From: Martyn White <Martyn.White@arun.gov.uk>
Sent: 24 September 2021 17:28
To: Planning.Responses <Planning.Responses@arun.gov.uk>
Subject: R/208/21/L

R/208/21/L

Herne Farm House 2 Park Drive Rustington BN16 3DZ

Listed building consent to replace 4 No. ground floor windows, a pair of glazed French doors and a part glazed external door in the northern modern extension to the original house.

Windows to be Replaced
Figure 3.1

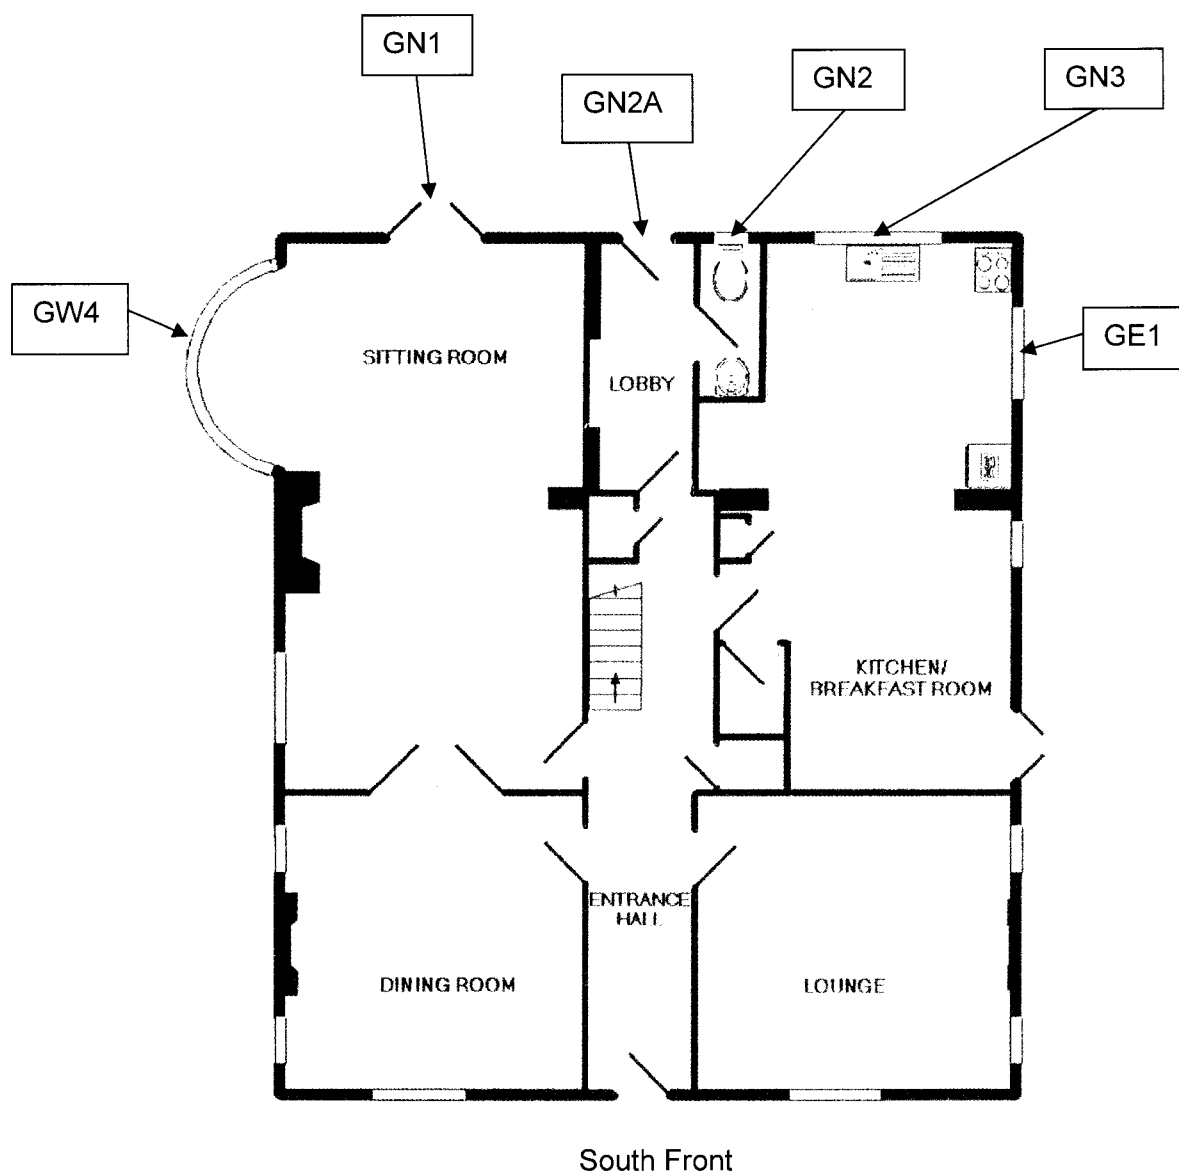
Having reviewed the information, I am of the opinion that based on their age and location within a modern extension to the rear of the house, that they are of no significance and can be replaced. The only issue is to ensure that the replacement windows and doors are appropriate for the listed building.

Paragraph 3.14 of the heritage statement identifies that the detailing of the new windows will be discussed and agreed with the Council's Historic Buildings Officer so that as far as possible the maximum thermal efficiency can be achieved consistent with preserving the significance of the building as a heritage asset and avoiding any further deterioration in its fabric. This approach is positive, and the relevant information can be supplied by way of condition, should you be minded to approve the application. Details of their design, specification, method of opening and finish, in the form of drawings and sections of an appropriate scale, shall be submitted to and agreed in writing by the Local Planning Authority before the windows and doors are installed. The works shall be carried out only in accordance with the agreed window and door details.
